December 20, 1988

RE: GRADING/PAVING FOR EL BUEN SAMARITANO UNITED METHODIST CHURCH  
(J-14/D76) ENGINEER'S STAMP DATED DECEMBER 12, 1988

GRADING AND DRAINAGE PLAN
FOR NEW PARKING LOT
EL BUEN SAMARITANO
UNITED METHODIST CHURCH
(7TH STREET N.W. & GRANITE AVENUE N.W.)
ALBUQUERQUE, NEW MEXICO
DECEMBER, 1988

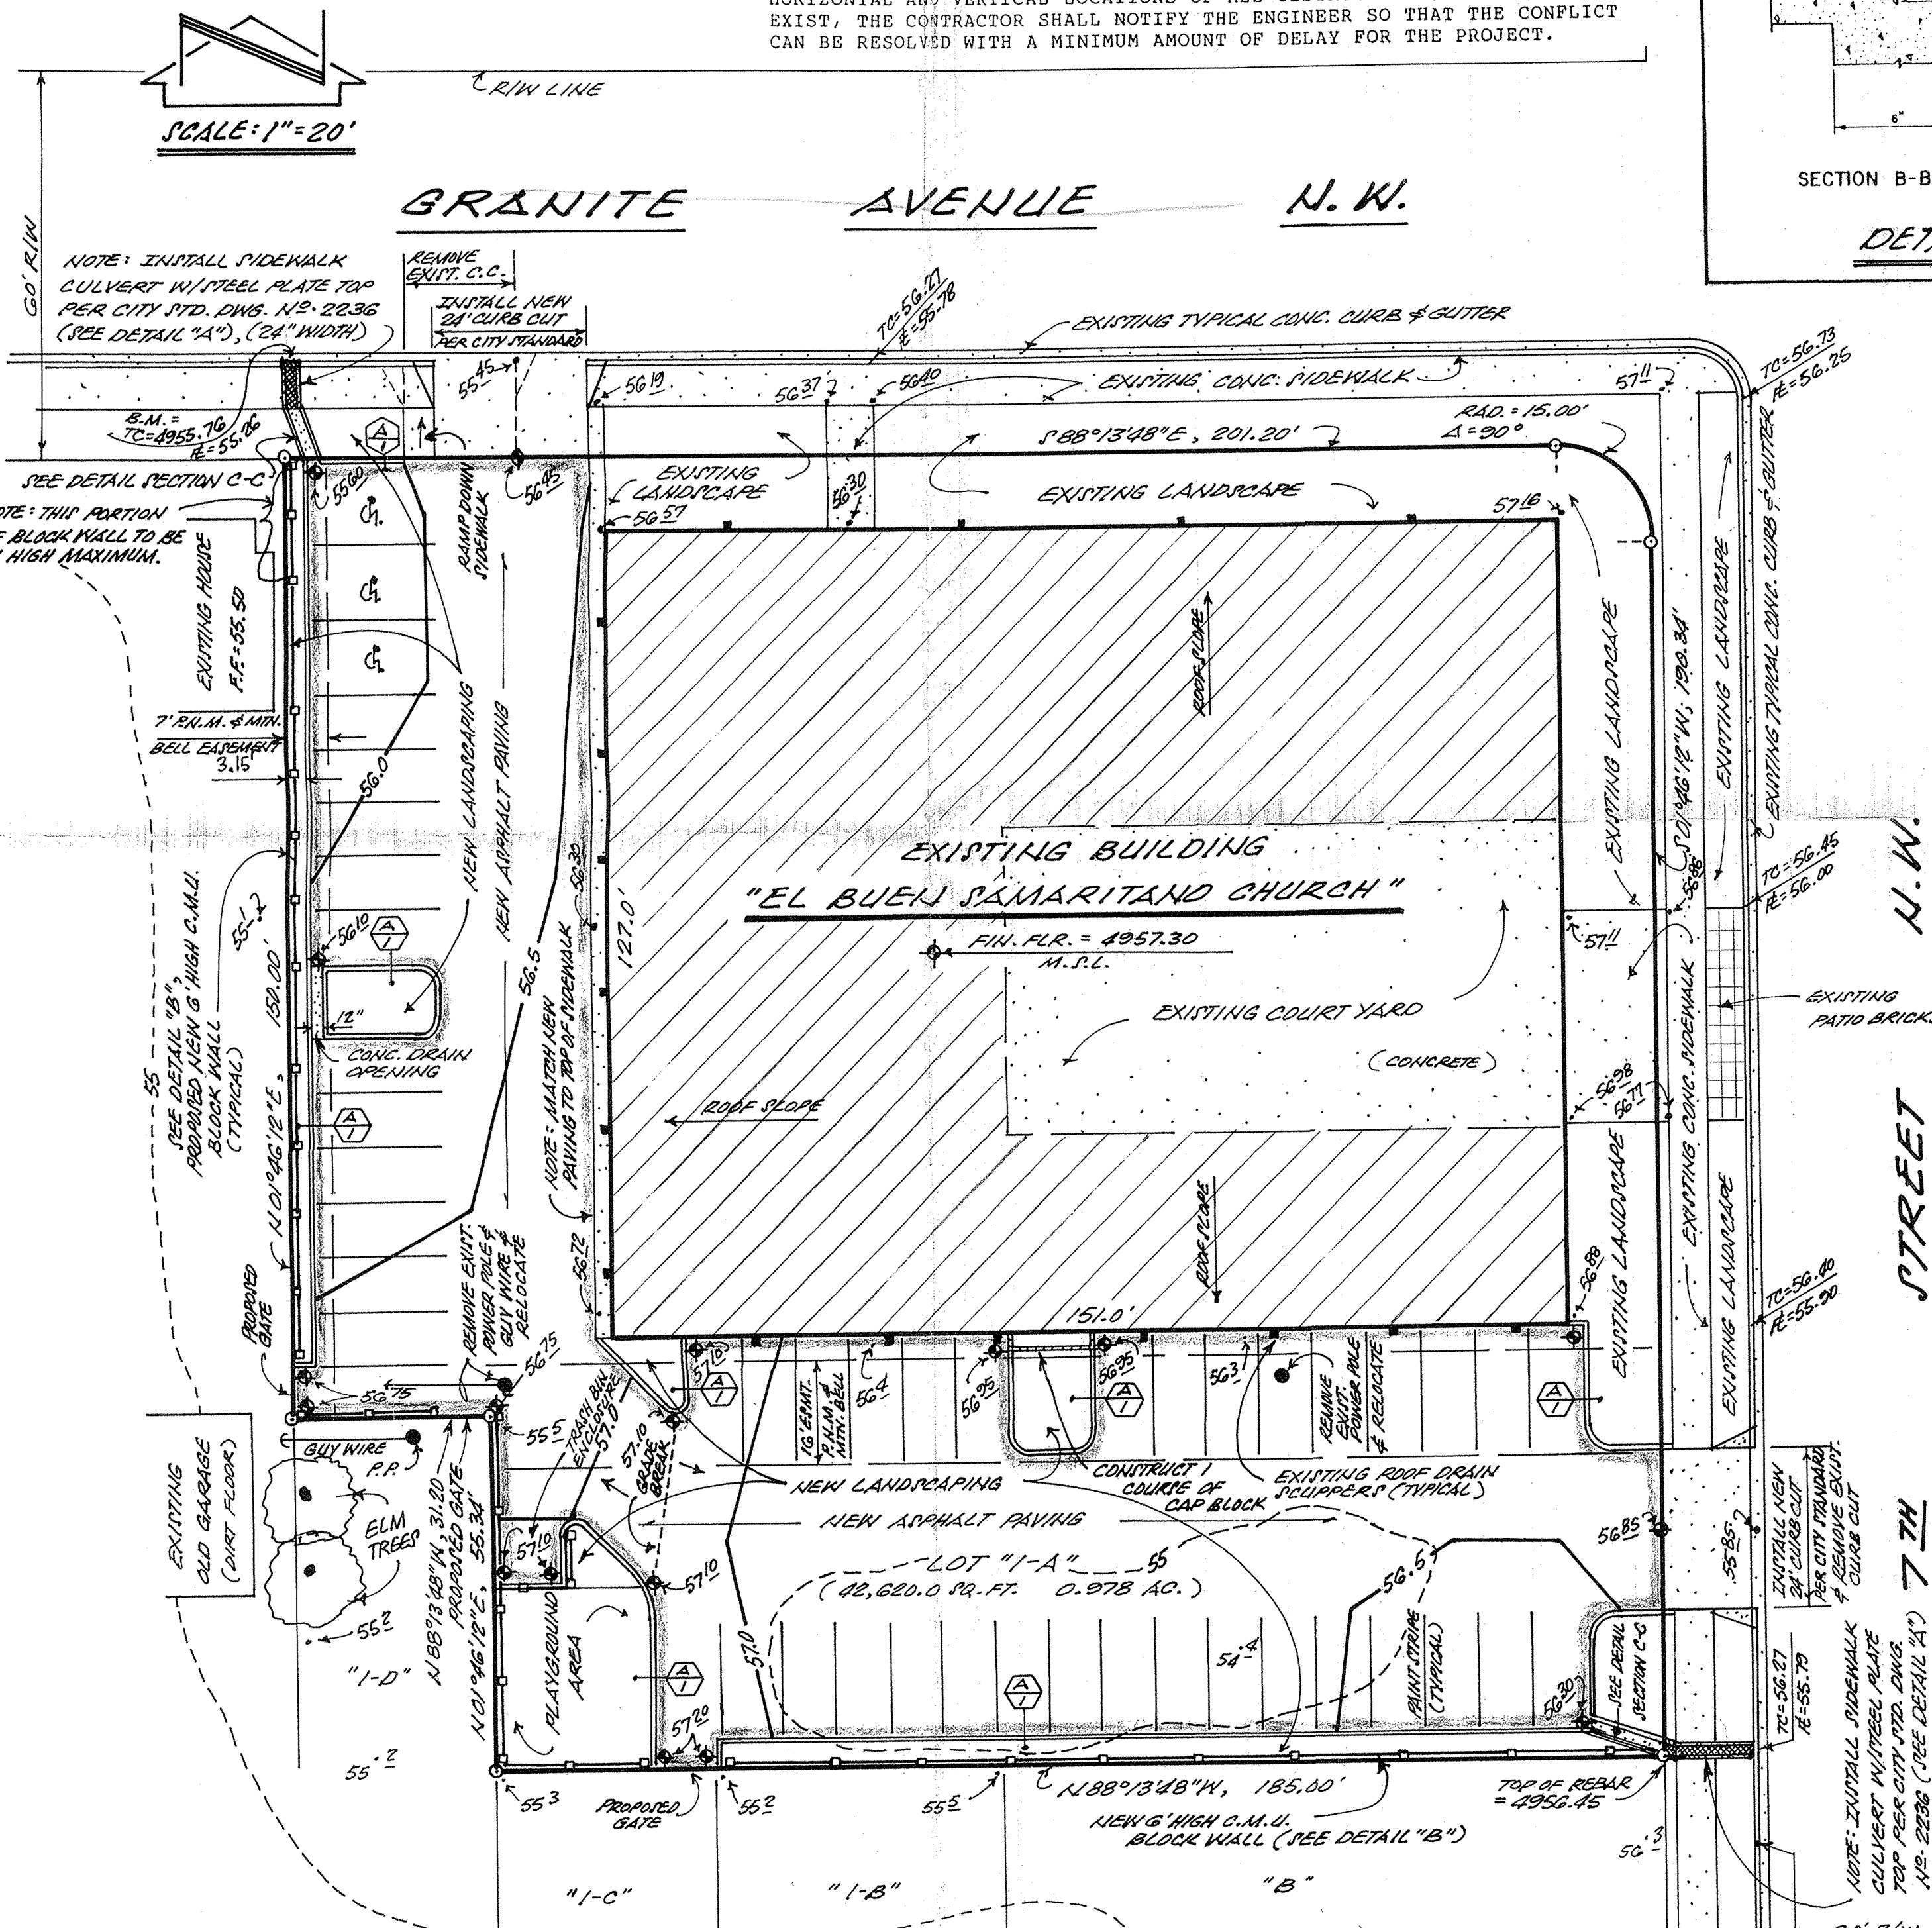
I have contacted Richard Dineen (Planning Department) and Victoria Prinz (Redevelopment Division) to inquire as to the meaning of the access provisions required by E.P.C. for Lot 1-C, 1-D, and Lot 4-A. They have advised me that they are considered for pedestrian traffic and not vehicular traffic. It would be advisable to consider installing railroad steps at each location for easy access onto the church parking area.
